CONSTRUCTION PLANS  
for  
**JACKSON RANCH FILING NO. 3**  
SECTION 21, TOWNSHIP 11 SOUTH, RANGE 66 WEST OF THE 6TH  
P.M., EL PASO COUNTY, COLORADO

**JACKSON RANCH  
FILING NO. 3  
COVER SHEET**

**APRIL 17, 2017  
SHEET 1 OF 5**

JACKSON RANCH
FILING NO. 3
COVER SHEET

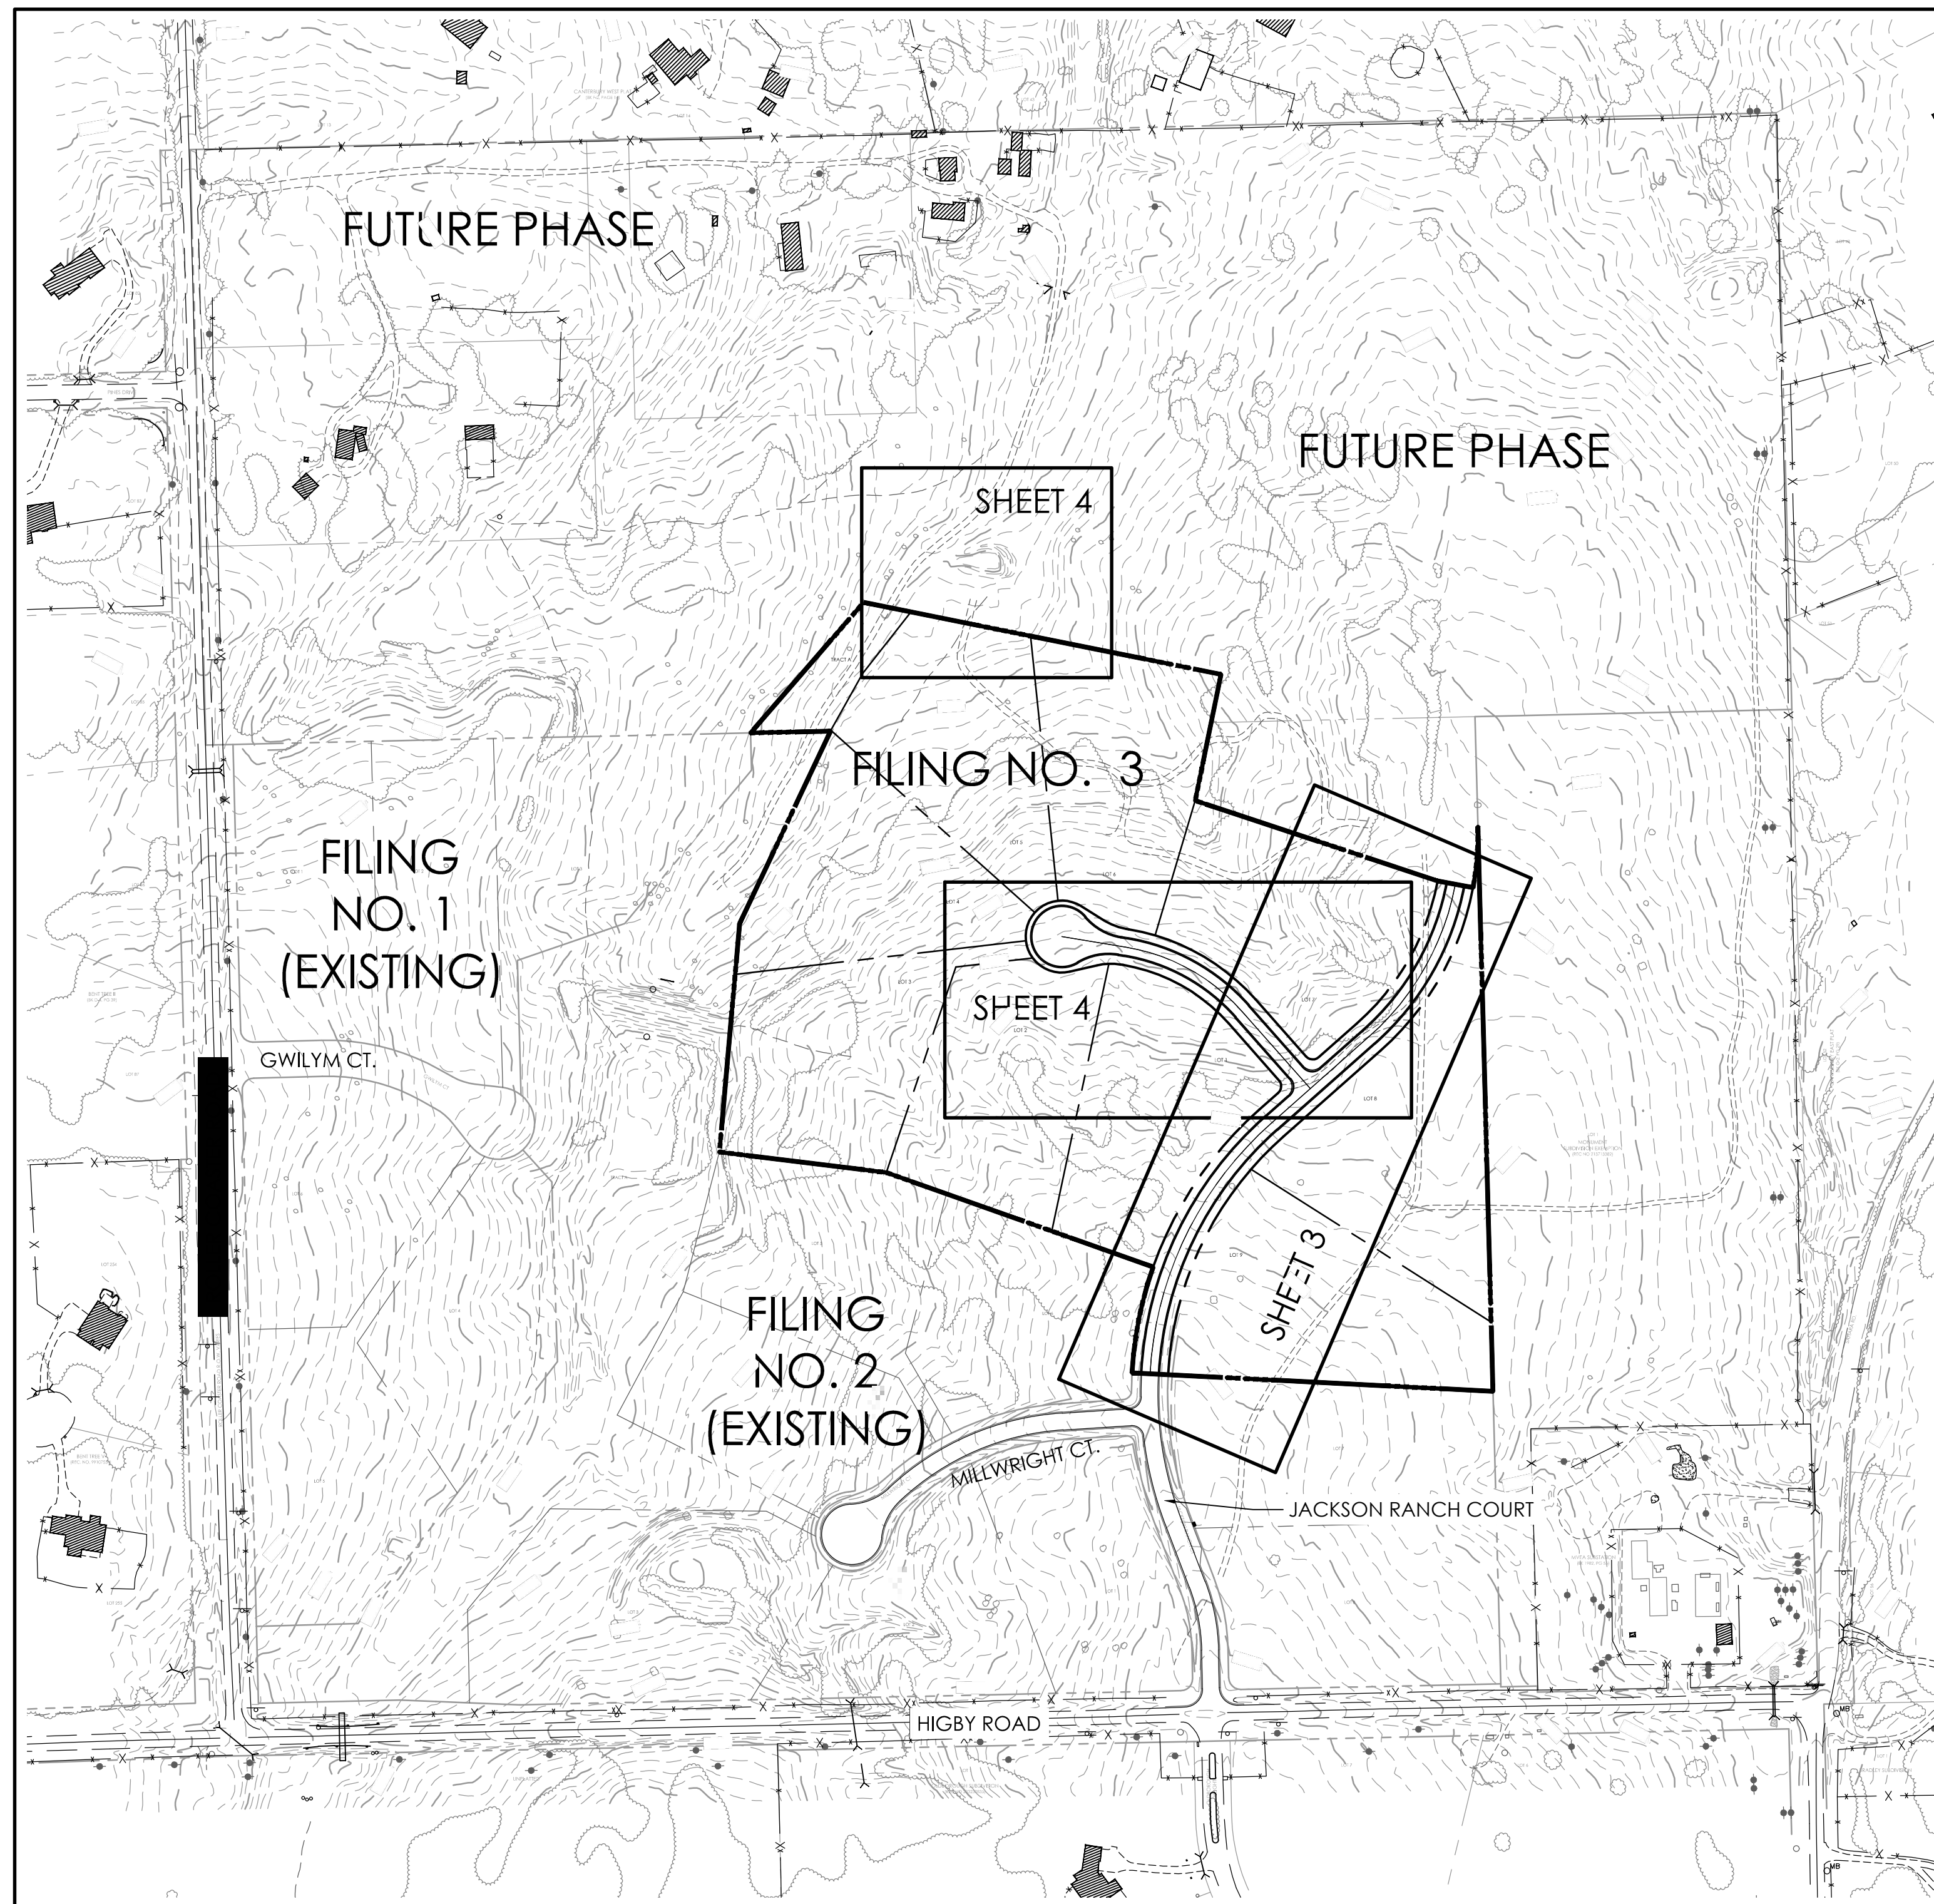
Add EPC Planning  
& Community  
Development  
Department.

Add "PCD Project  
No. SF-17-017"

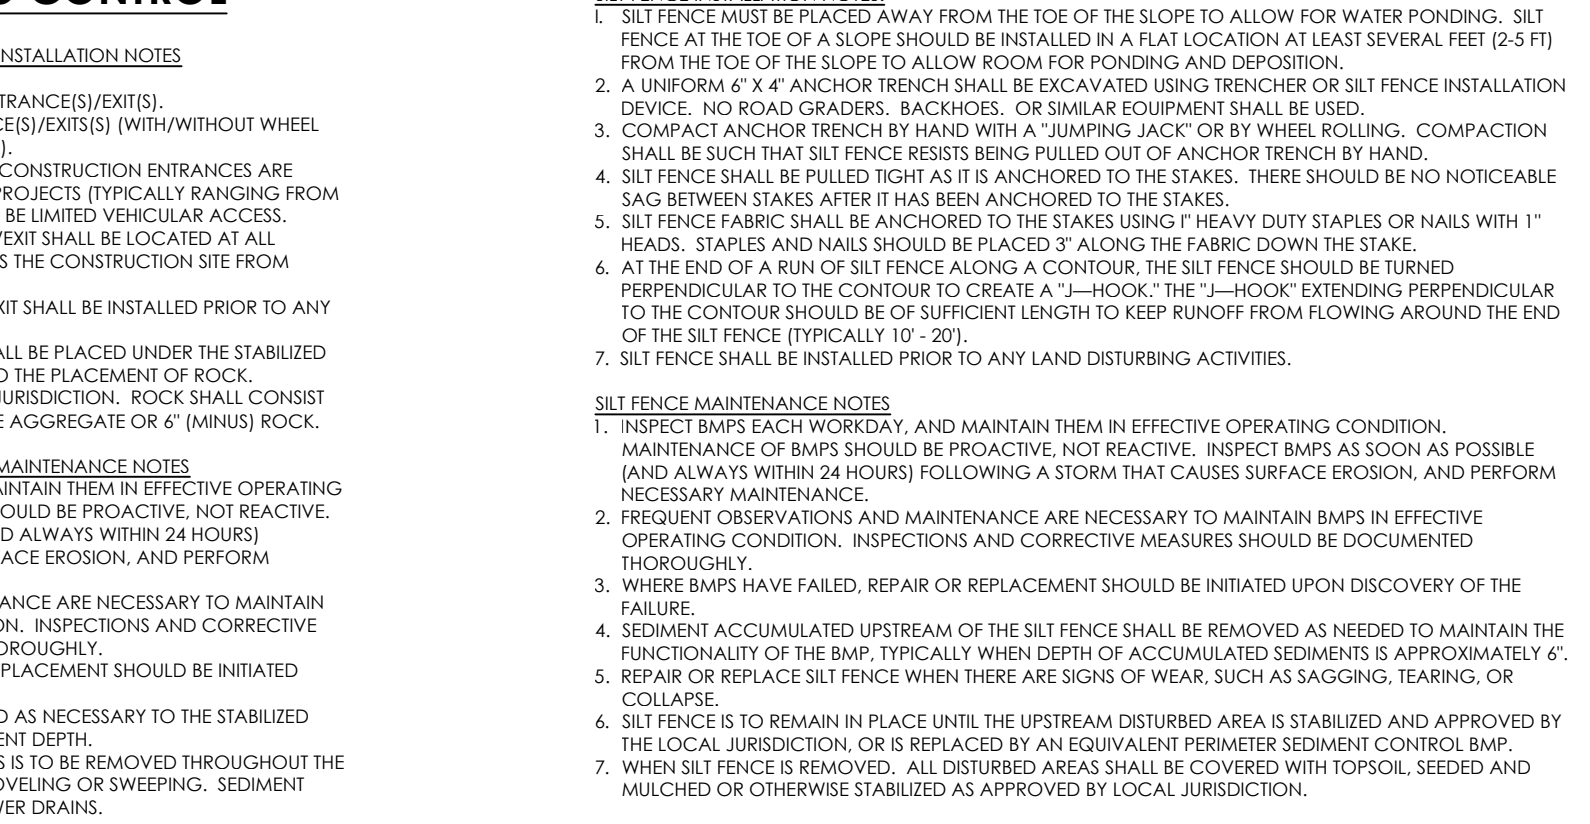
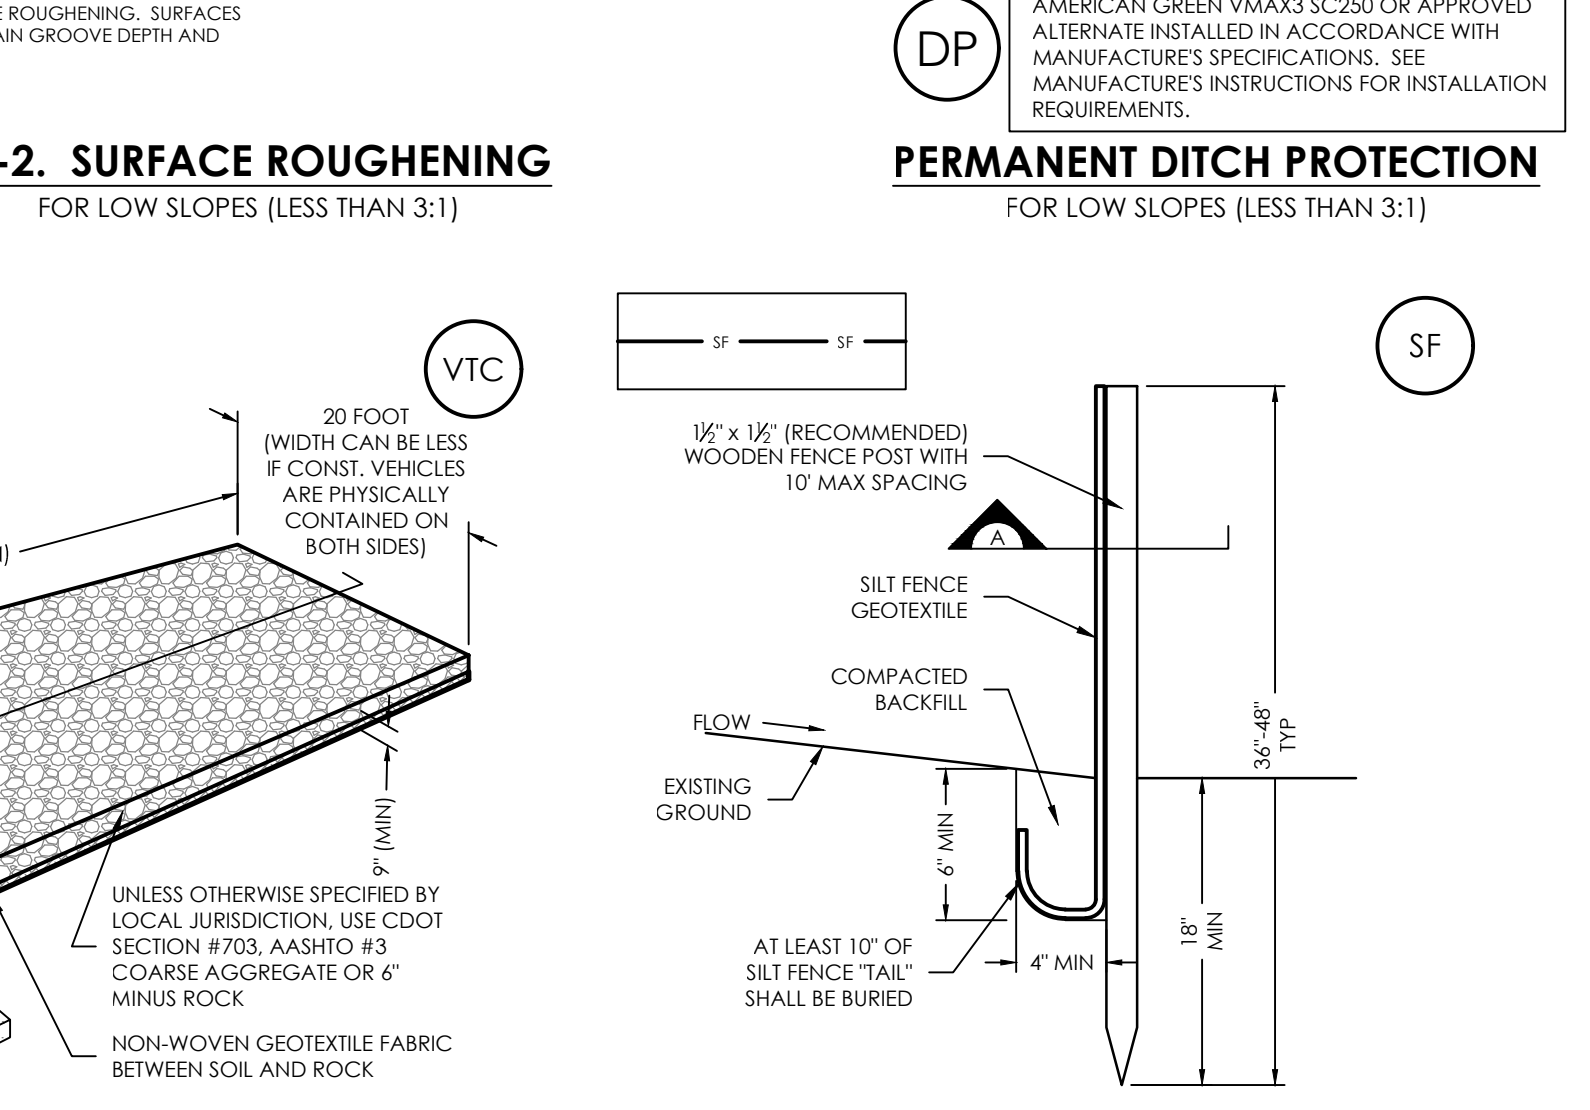
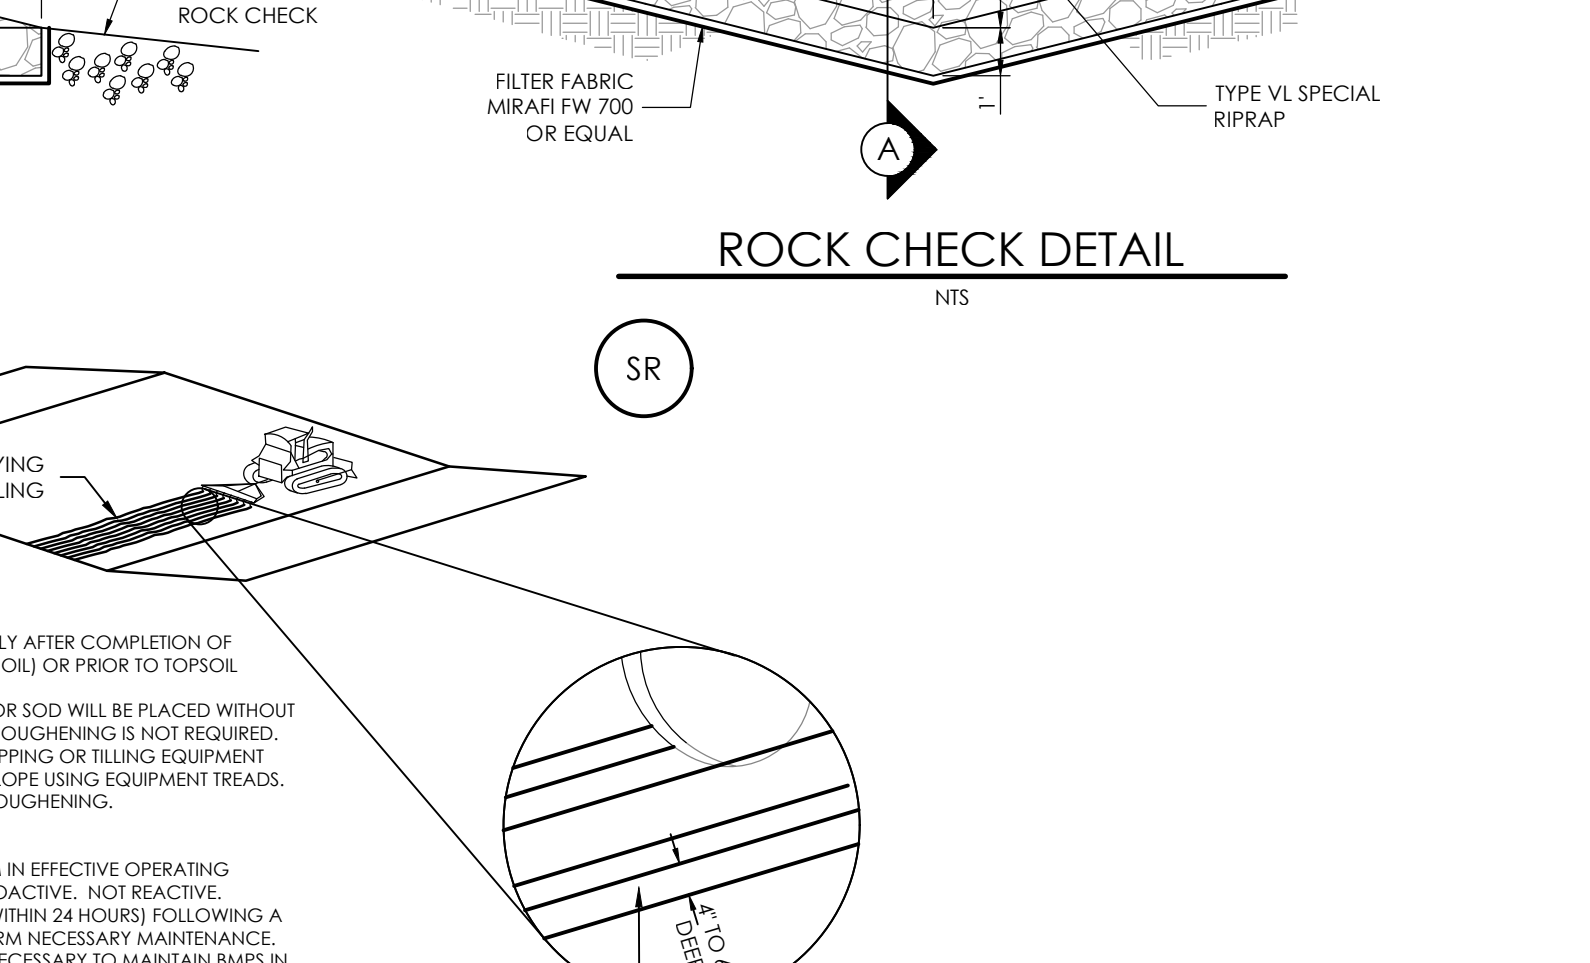
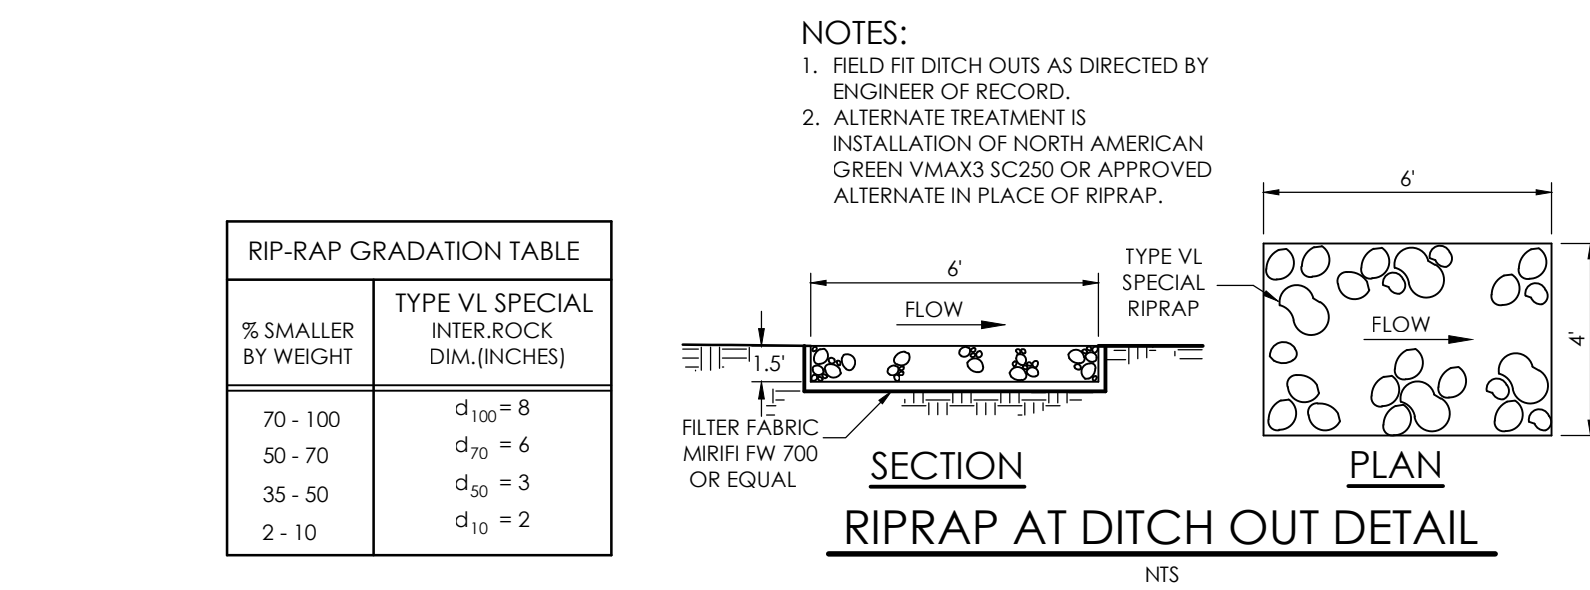
Show aggregate base course.

Revise to SD-2-76
